Submission form: environmental impact statement(EIS)

Narrabri Gas Project – SSD 6456 (Santos EIS)

Comments on EIS – Chapter 26

Figure 26-2 Potential health impacts and exposure pathways

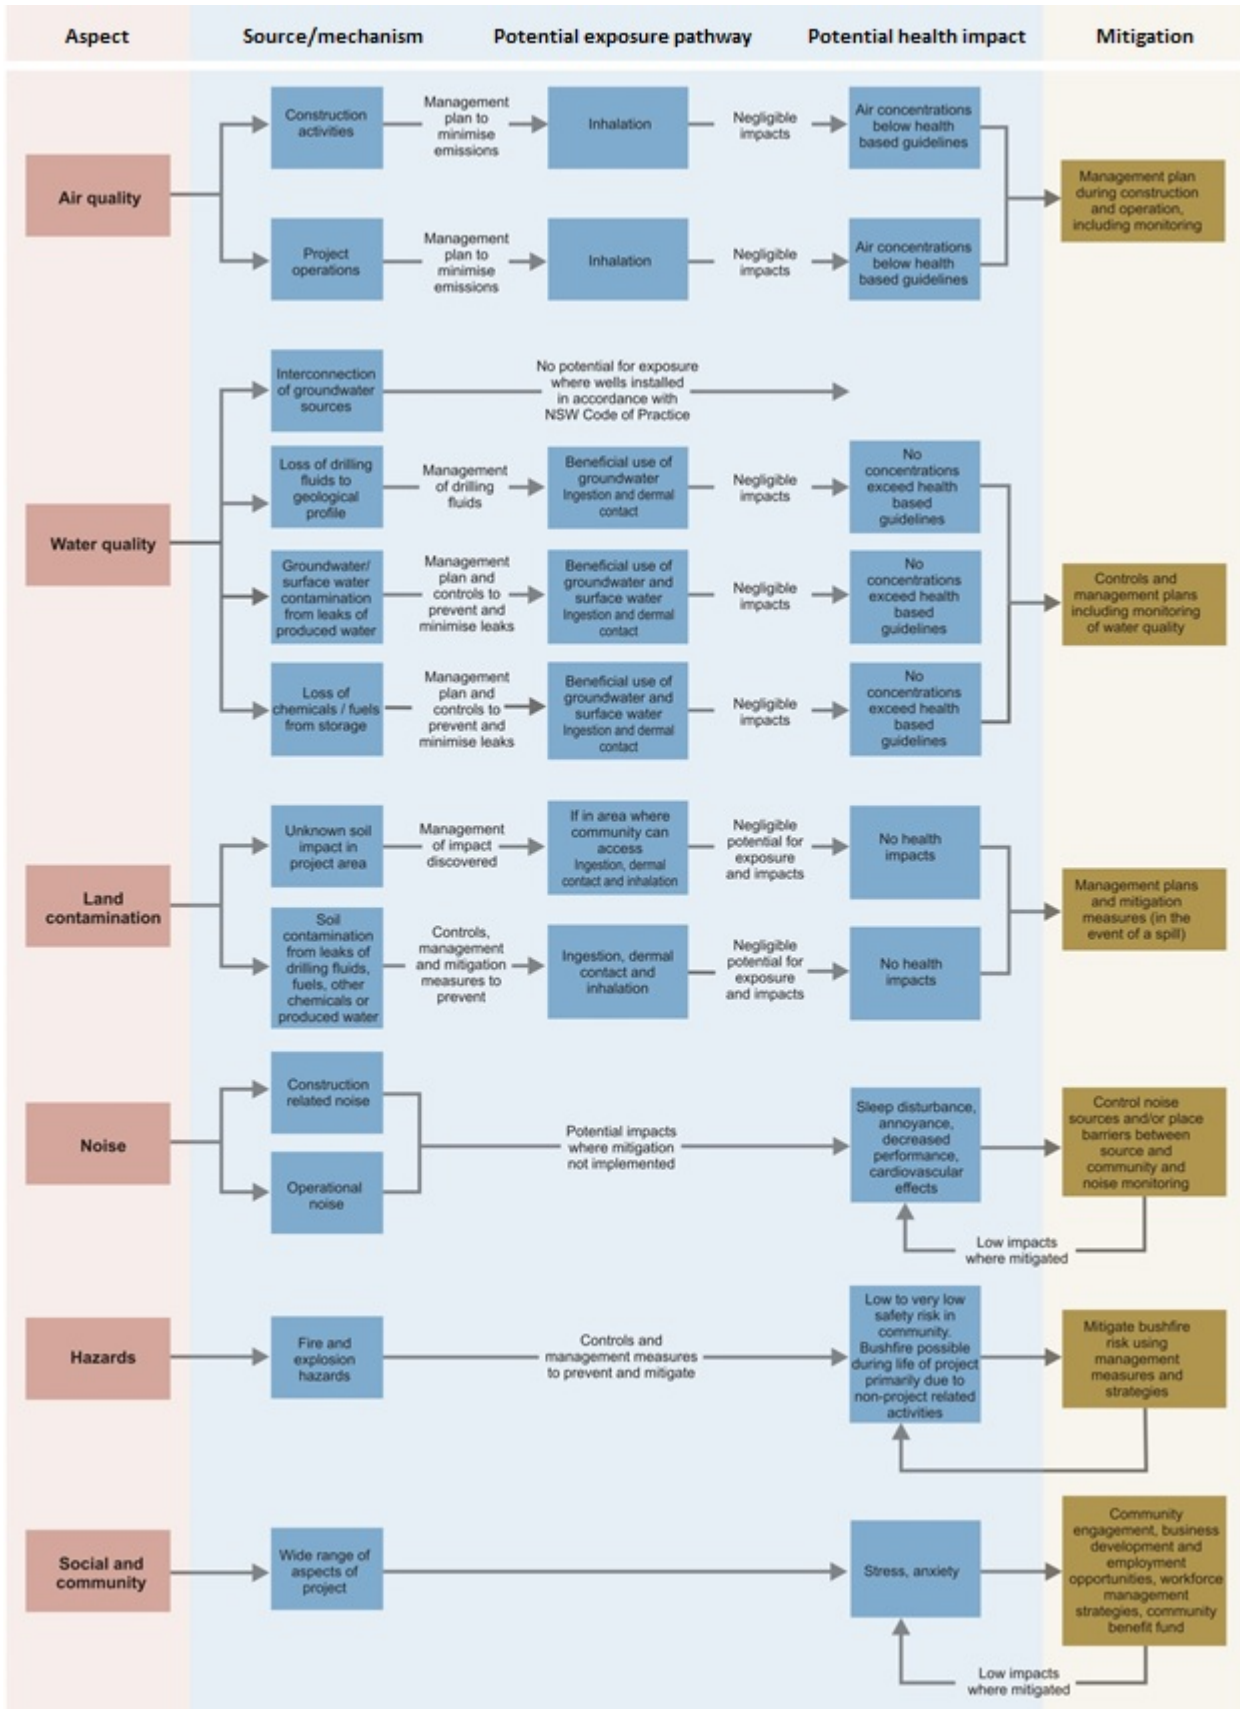
26.3.6 Health and Wellbeing	<p>I am concerned that Figure 26-2 is illegible, an ability to read this table has hindered the ability to provide comments. Checked this figure in Appendix T2, and again it illegible.</p> <p>Reviewing Appendix T2, Section 2.4 Specialist/Technical Reports – I made attempts to locate some of these reports, however it would seem that these reports are not for public viewing.</p> <p>EIS would need to provide all this information to enable community comments.</p>	<p>Figure 26-2 is to present in a form that is about to be read to allow comments to be provided. This is direct indication that Santos is <i>not willing</i> to be open, honest and transparent.</p> <p>As the saying goes, 'he who pays, wins' – GHD and specialist consultants are paid by Santos to supply reports with a desired outcome. This desired outcome is to support the project proceeding, otherwise the consultants' work will not be paid.</p> <p>A project such as this, requires third party, independent and peer reviewed studies – the research needed must not have any form of conflict of interest to ensure that the desired outcomes are neutral and best for the future. This has not occurred within this EIS and all statements made are biased to favour Santos.</p> <p>Appendix T2 – Section 2.5 Limitations; this defines the scope of the health impact assessment has been limited to discussion of the potential effects of health due to only those matters covered/introduced in the specialist studies listed in Table 2-1. This clear admission of narrowing the studies to only include (in majority) of the cases to research that Santos has commissioned, is a FLAWED approach and a clear warning to EPA that there are serious information gaps being presented in this section of the EIS (amongst the other Chapters).</p> <p>The solution is to engage independent 3rd party researchers to conduct long term studies (baselines) and consult with the seriously impacted community residents to provide a truly neutral and unbiased report and outcomes. Anything less than this is unacceptable for the community and this EIS should not be approved.</p> <p><i>George Bender:</i></p> <p>The following explanation has been researched from A page from Bully Online, website of the UK National Workplace Bullying Advice Line:</p> <ul style="list-style-type: none"> Whilst some people decide to end their life because of despair, others take their life because they see it as a "logical step". It is thought that the former category (despair) is the result of "mental illness", whilst the latter (logical step) is because of "psychiatric injury". The difference is important because injury has an external cause - in other words, something - or someone - is liable. The differences between mental illness and psychiatric injury are often not recognised; understanding the differences could alter the verdict, perhaps from suicide to manslaughter.
